CITY OF PORTLAND BUILDING PERMIT

PERMIT ID: 2013-00396

has permission to **Change of use from landscaping business to retail & wholesale of commercial fishing equipment & manufacturing of wire lobster traps - no construction**

Jonathan Rioux - Re: 222 Riverside Street

**PORTLAND TRAP  
CROSS SECTION - MAIN BUILDING**  
SCALE: 1/4" = 1'-0"

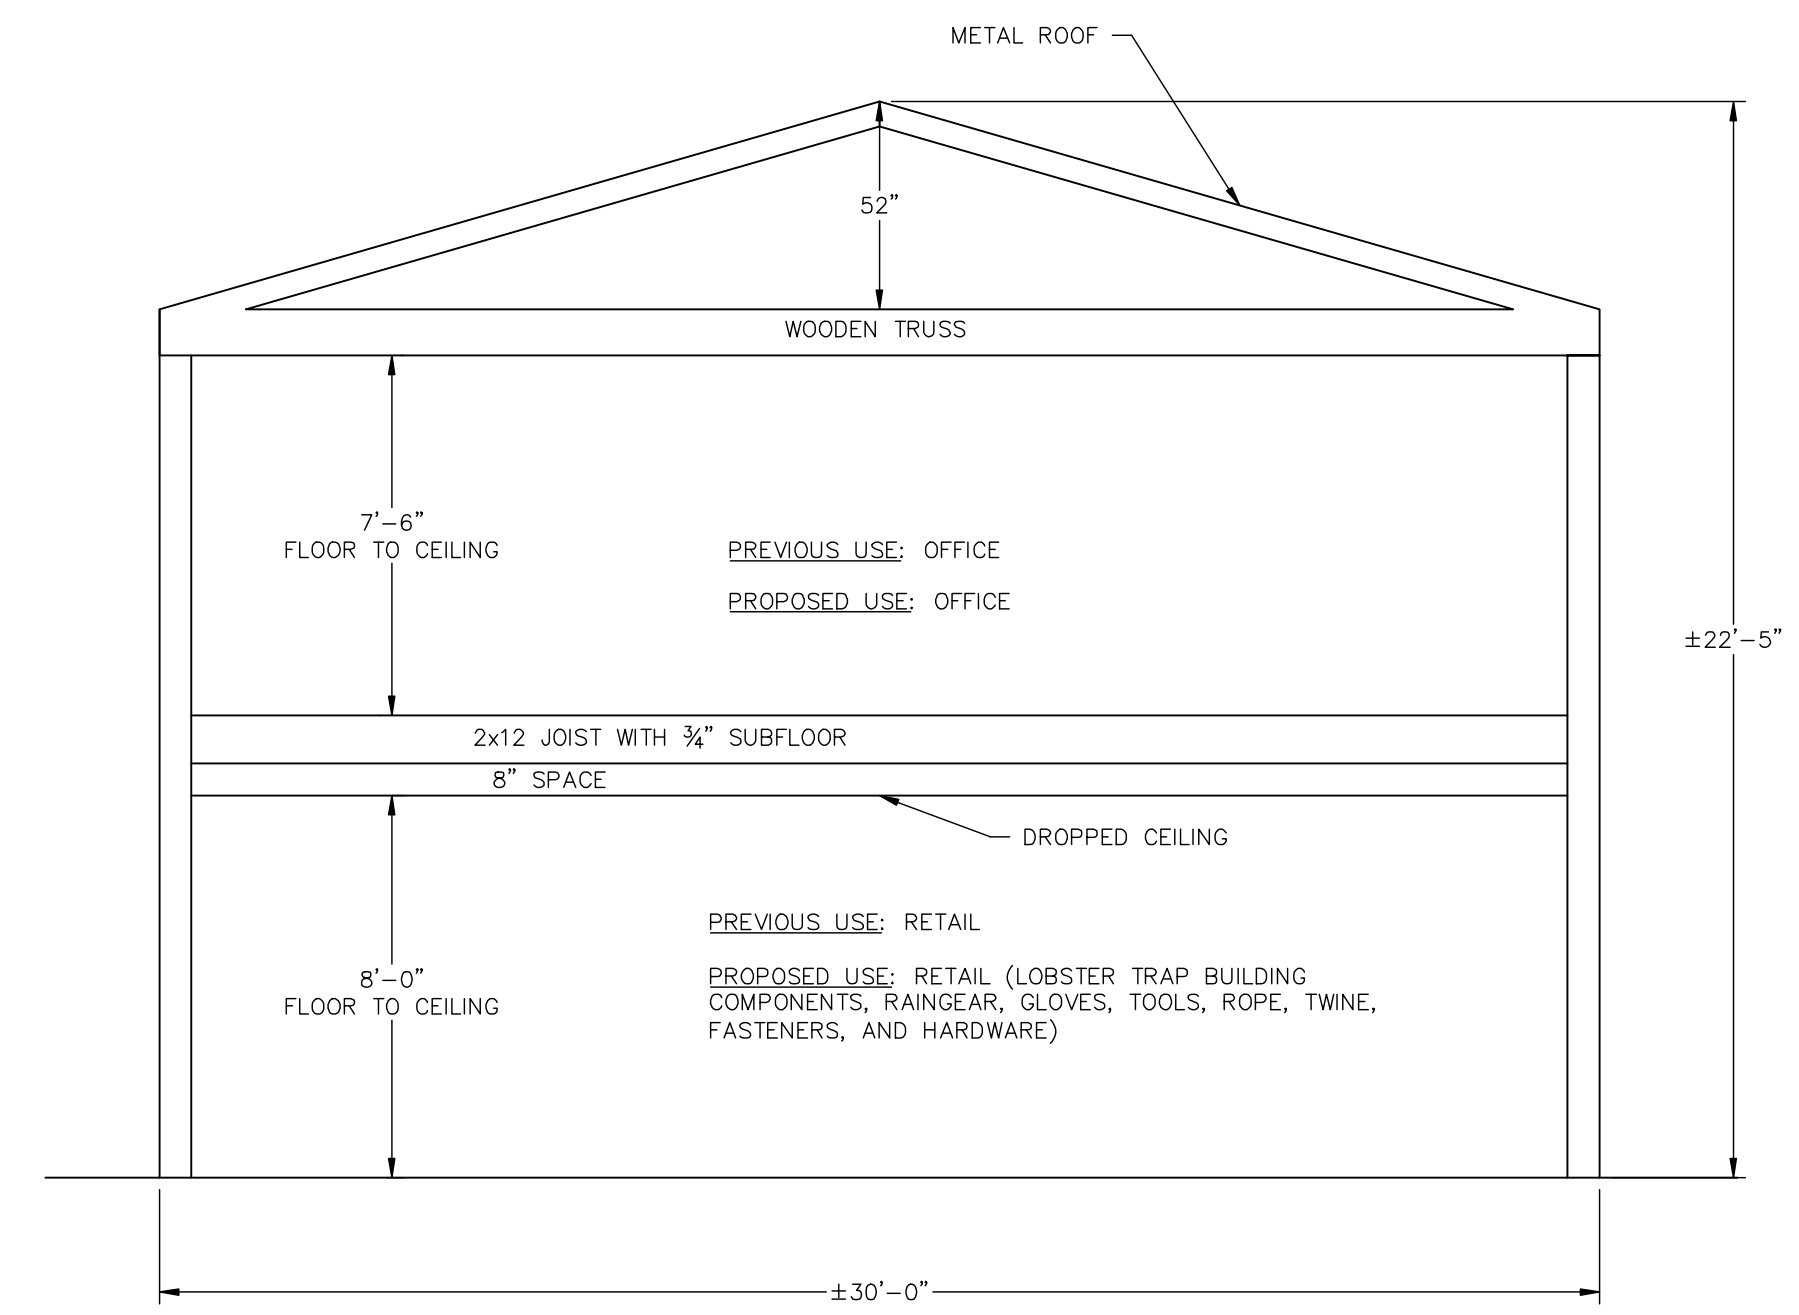
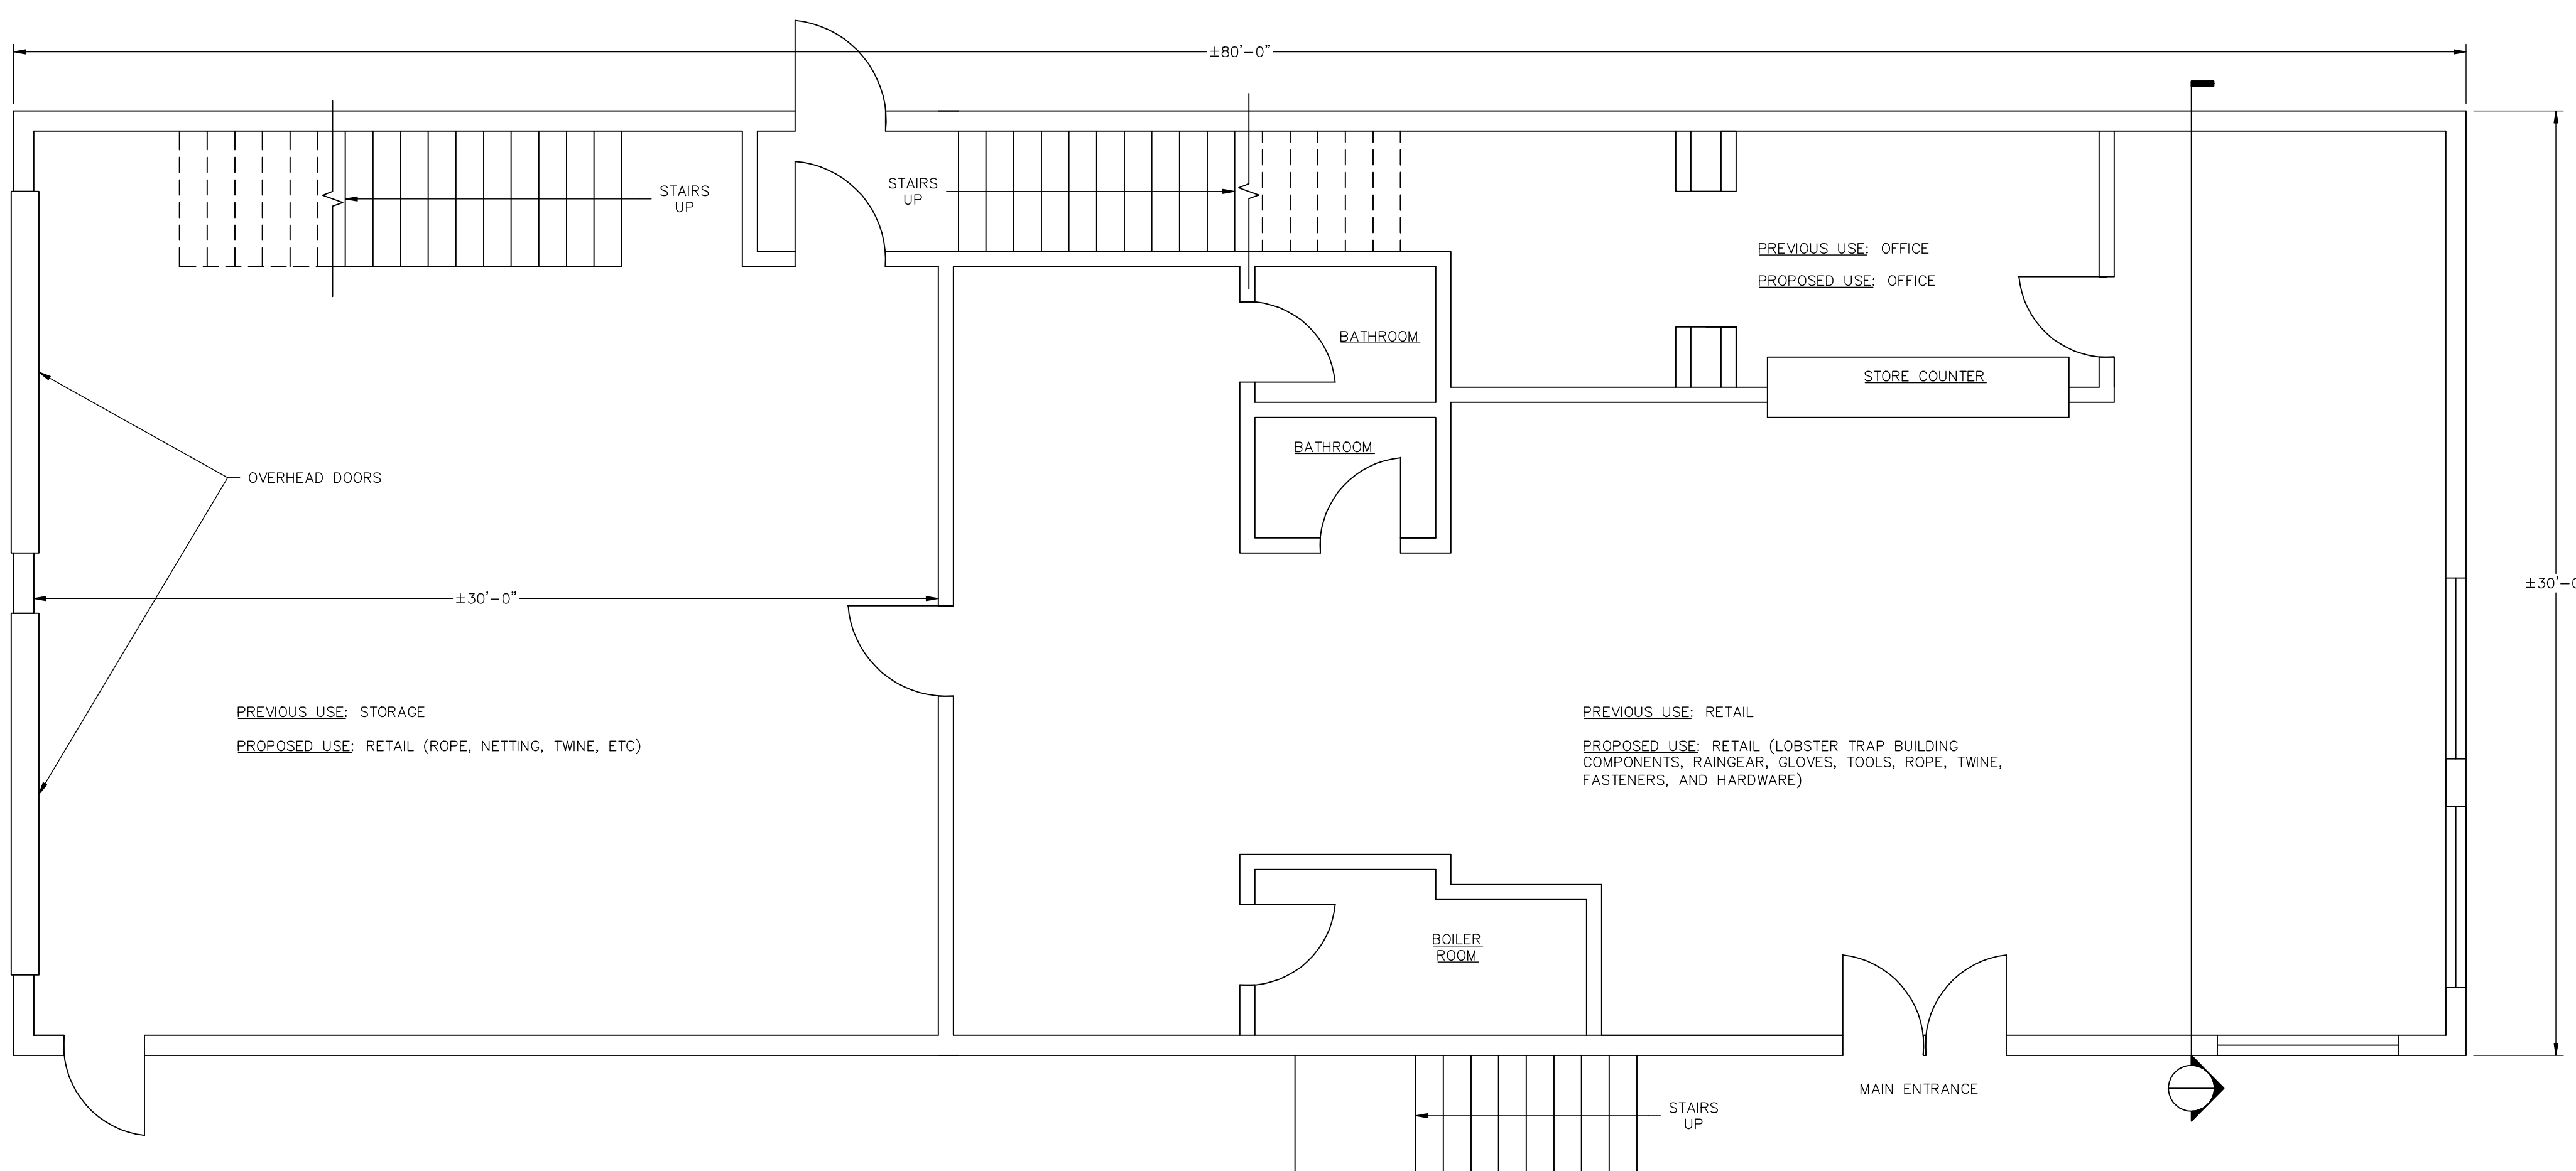
If the building is a M Retail or Wholesale Stores & F-2 Metal Products (Fabricating and Assembly) Table 508.4 requires a 1 hour separation of occupancies for sprinkled buildings or 2 hours for non sprinkled.

Are these uses separated from the first floor to the second floor offices and storage?

Is there a mezzanine or is it a full second floor?

Can you clarify, this project may need a design professional depending on the proposed uses?

Mark please submit new drawing, cross-section and floor plans indicating the information identified on the attached document.

**PORTLAND TRAP
SECOND FLOOR PLAN - OUT BUILDING**
SCALE: 1/4" = 1'-0"

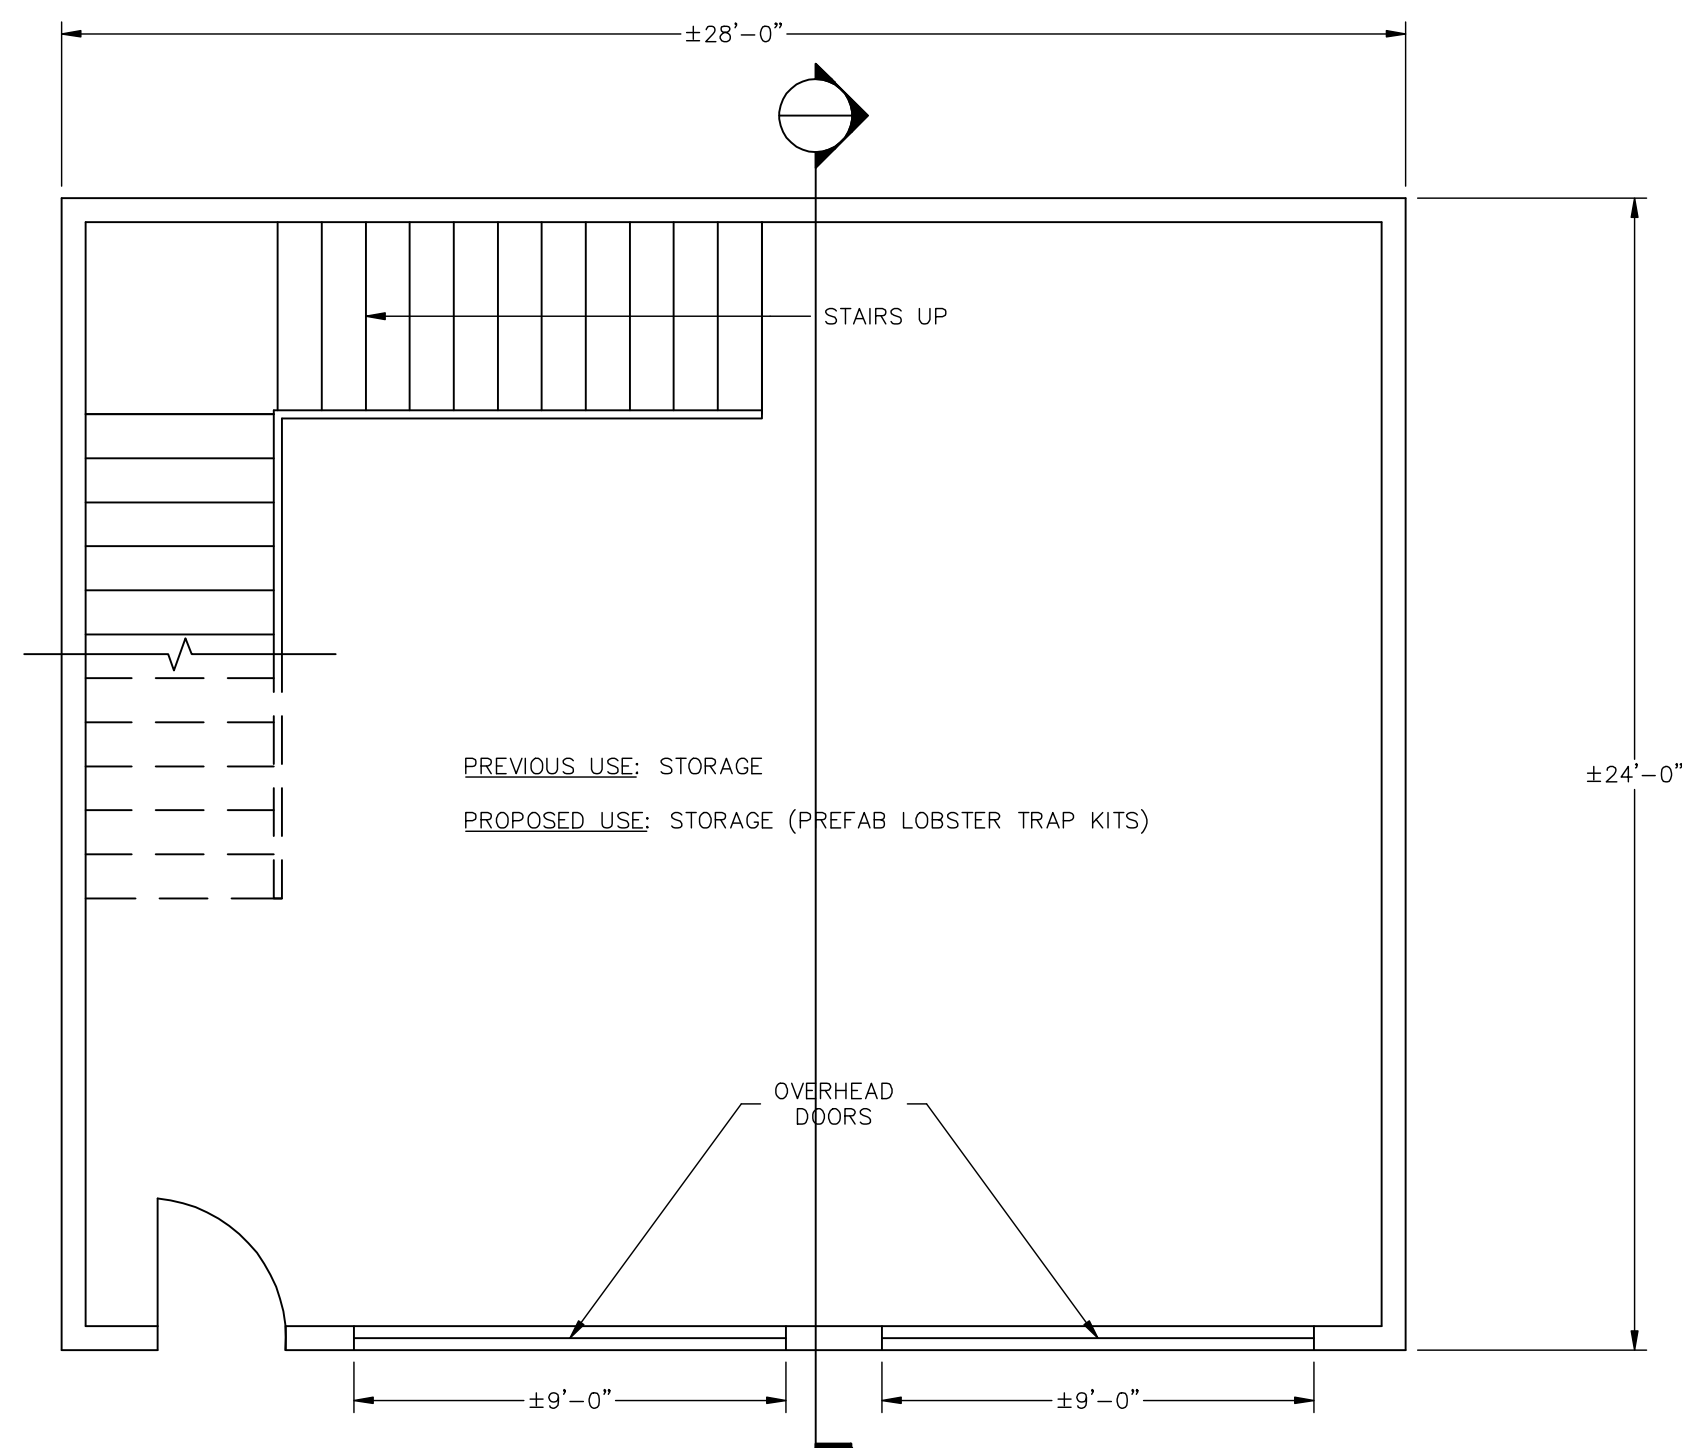
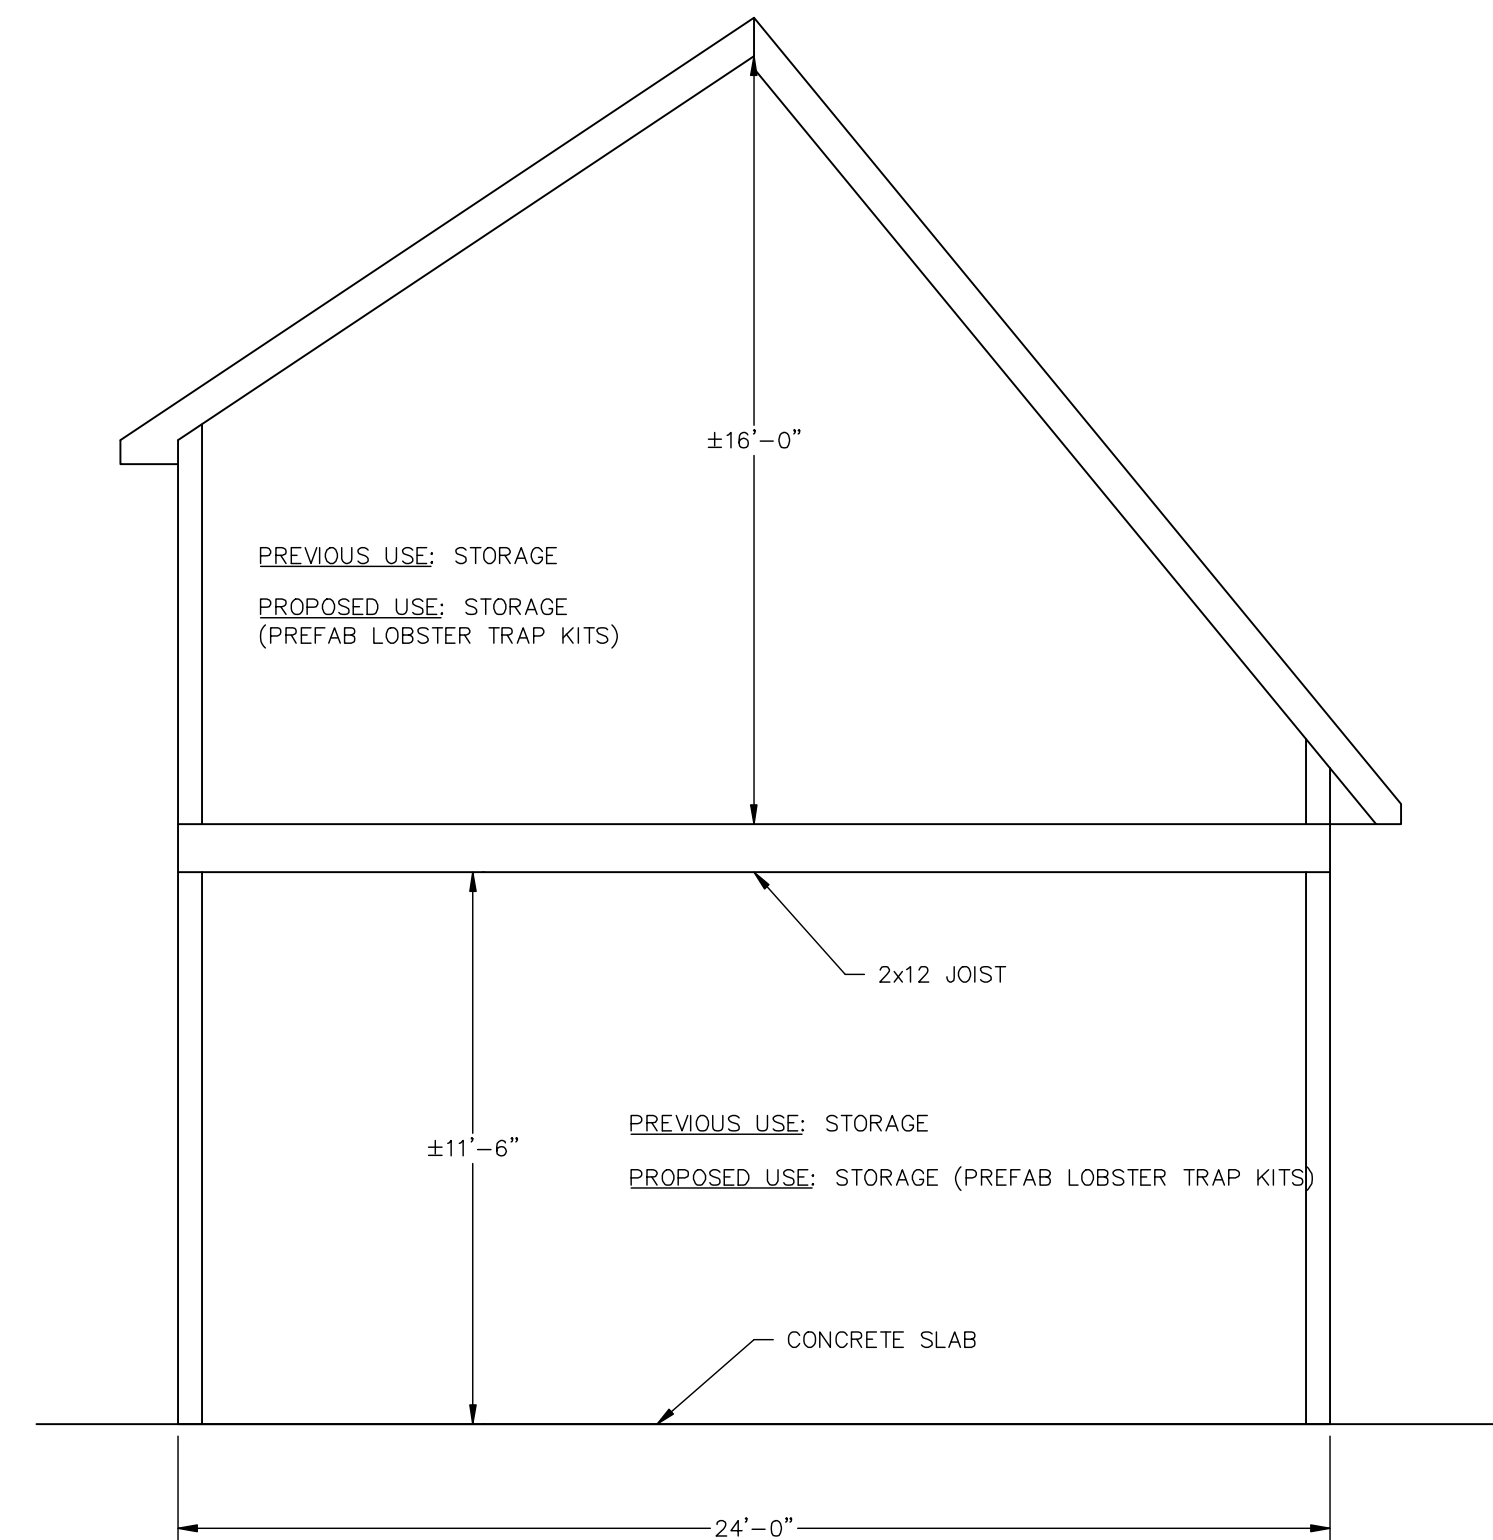
Are you manufacturing at this location (222 Riverside St.)?
